WA/120/21/DOC

Days, Days Lane Aldingbourne BN18 0TA

Approval of details reserved by condition imposed under WA/55/21/L relating to conditions 3-sample panel of flint work & 4-details of landscape works.

Plans and elevations as proposed

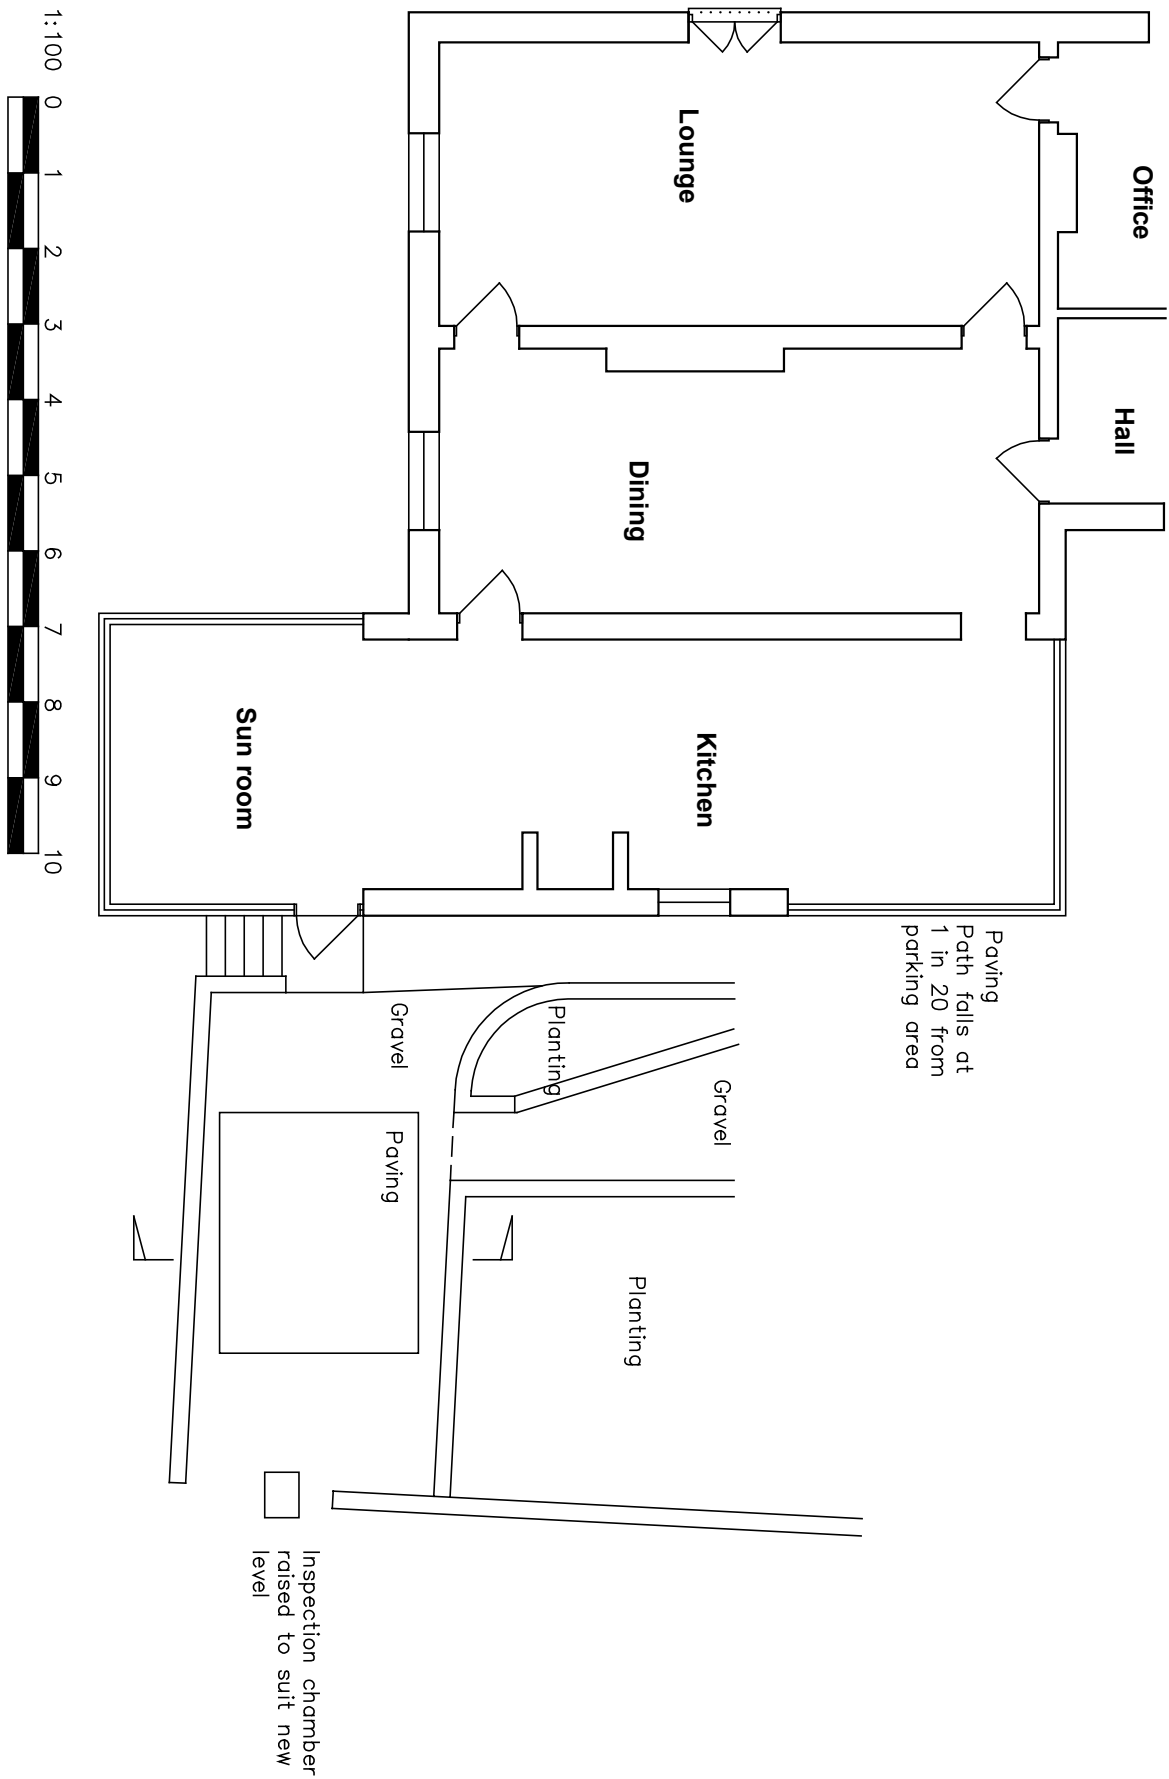
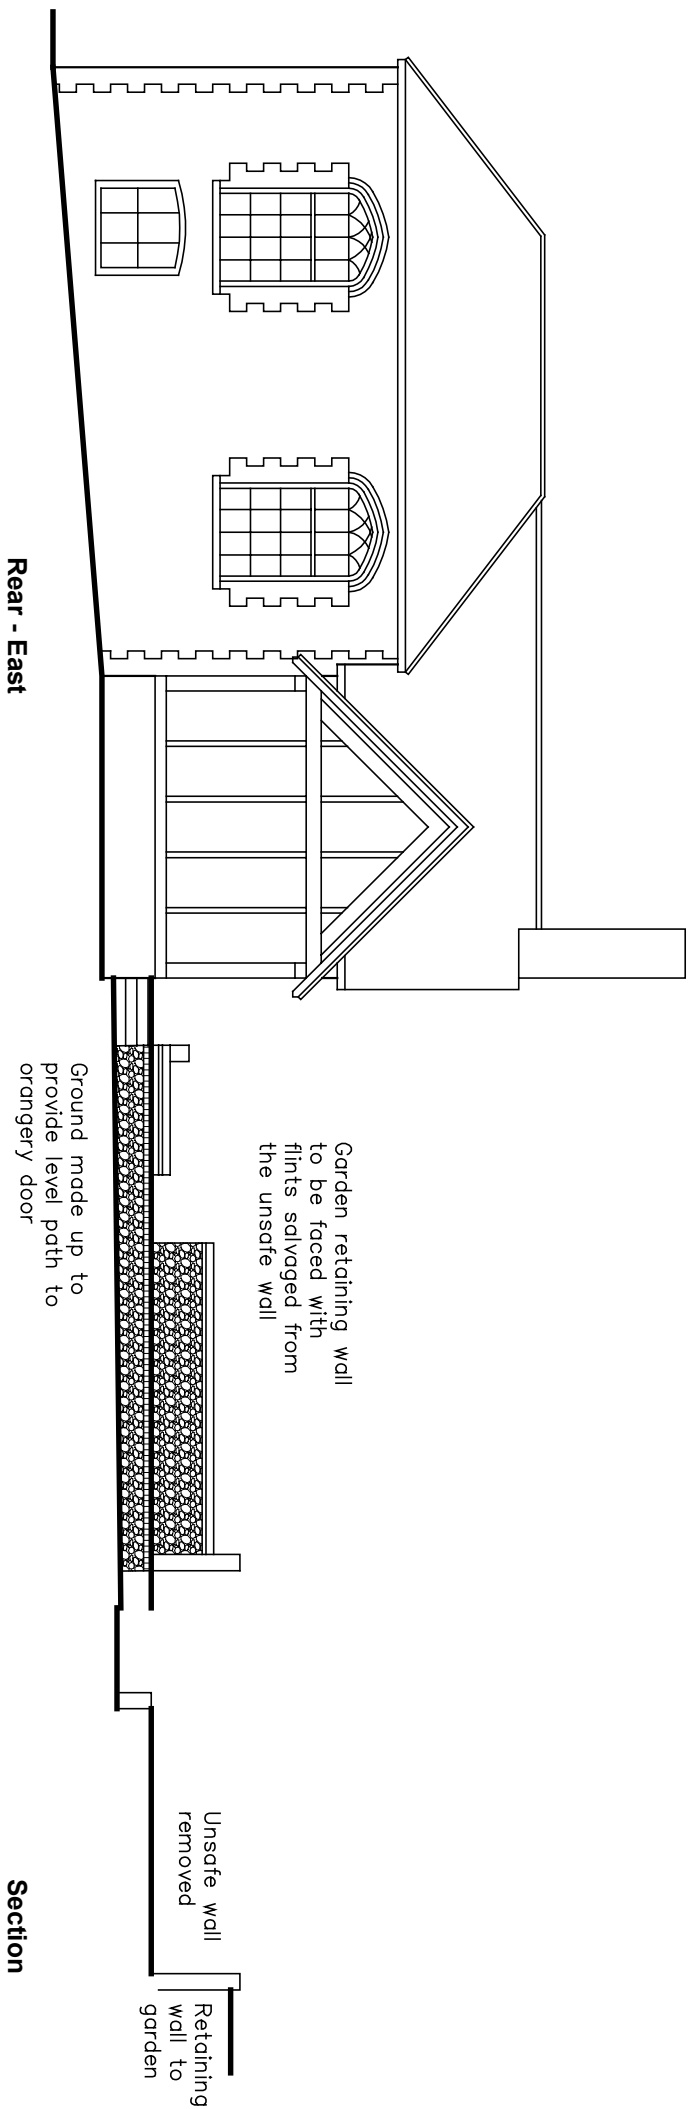
Whilst reviewing the plans submitted as part of this discharge of condition application, I have noticed that they appear different from those provided as part of the approved application. The retaining wall is not to the design of the approved plans in that it is now reduced in width and a small planter has been constructed in an area where the wall should have extended to. I also note an additional section of flint walling and altered landscape proposals (i.e. the level path is now wider).
